## WEST SUSSEX COUNTY COUNCIL CONSULTATION

| <b>DATE:</b>                    | 9 June 2021                                                                                                                                                                                                                                                                                                            |
| <b>SUBJECT:</b>                 | FG/87/21/PL<br><br>1 No. new unit in roof space plus reconfiguration of approved dwellings & other changes including retention of flat roof extensions and new dormers to courtyard elevation (revised application further to permission granted under FG/105/20/PL). This site is in CIL Zone 4 (Zero Rated) as flat. |

Proposed Block Plan

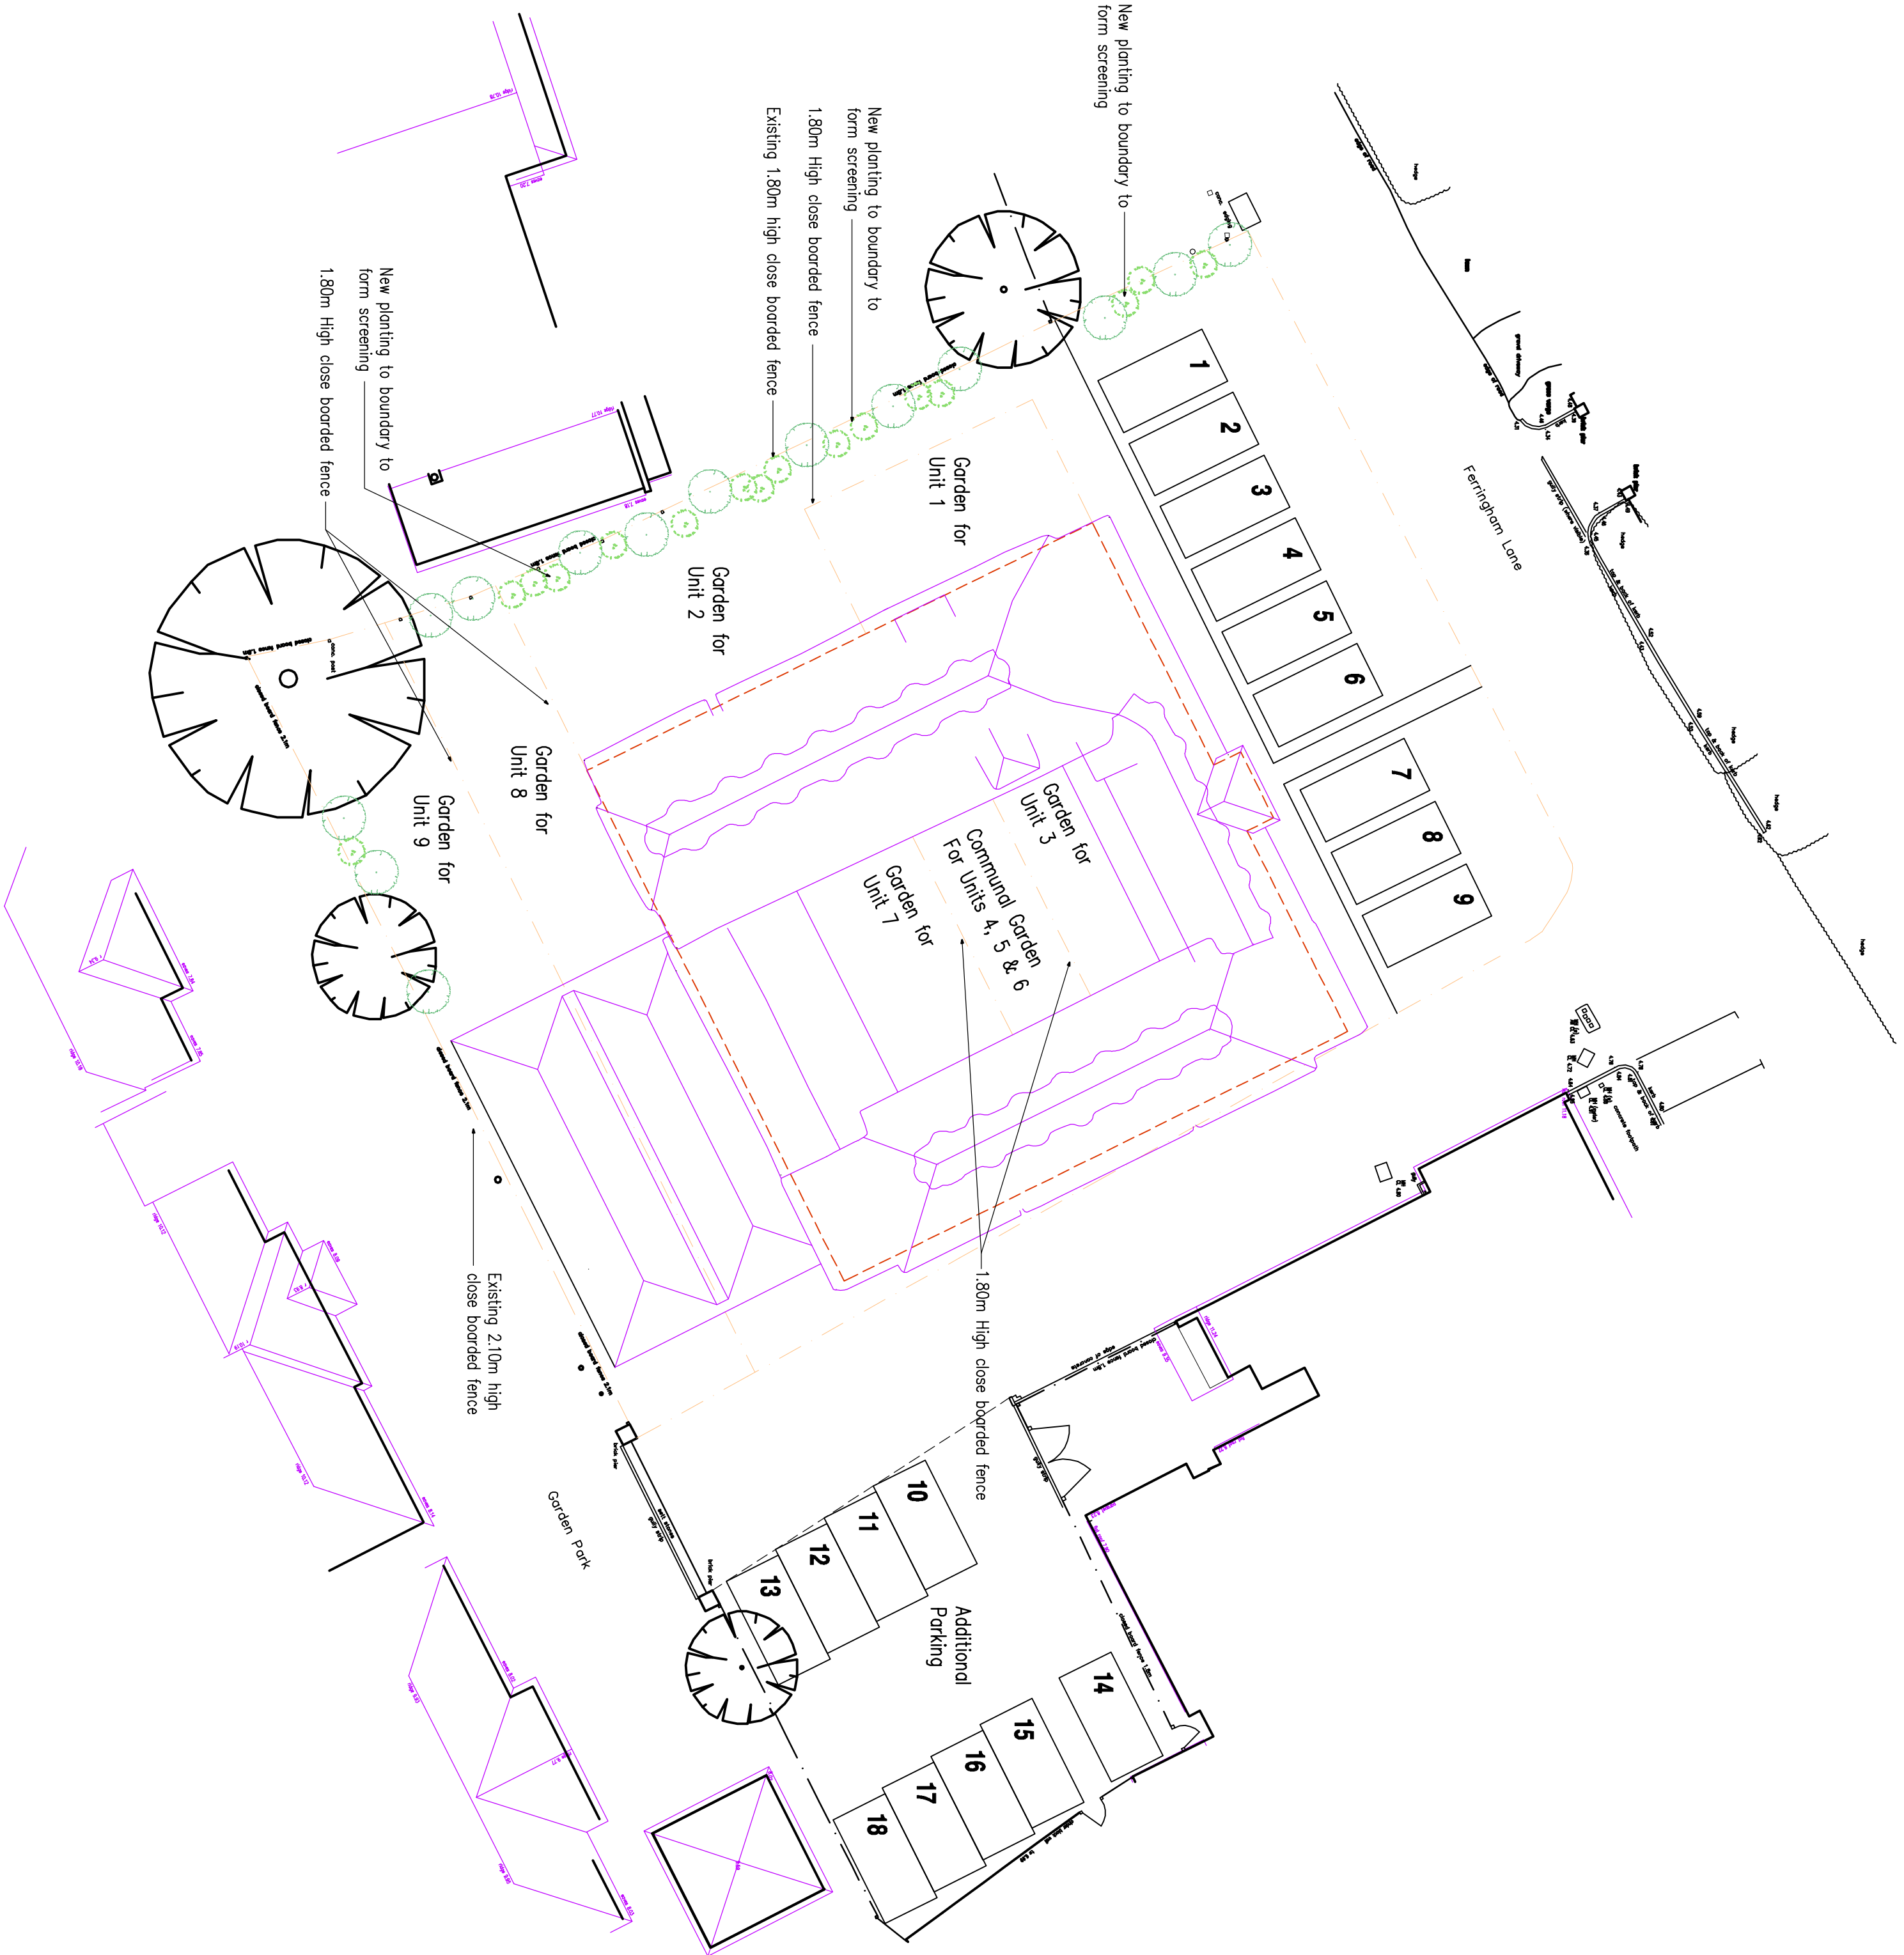
The principle of this application has been approved under FG/105/20/PL. The proposed site plan does not demonstrate the full parking layout. While one additional unit and the re-configured units from 1 to 2 bedroom would not alter the amount of parking provision required for the development, details of the parking spaces should be demonstrated on a revised plan or secured via planning condition included below.

No part of the development shall be first occupied until the car parking spaces have been constructed in accordance with plans and details to be submitted to and approved in writing by the Local Planning Authority. These spaces shall thereafter be retained at all times for their designated purpose.
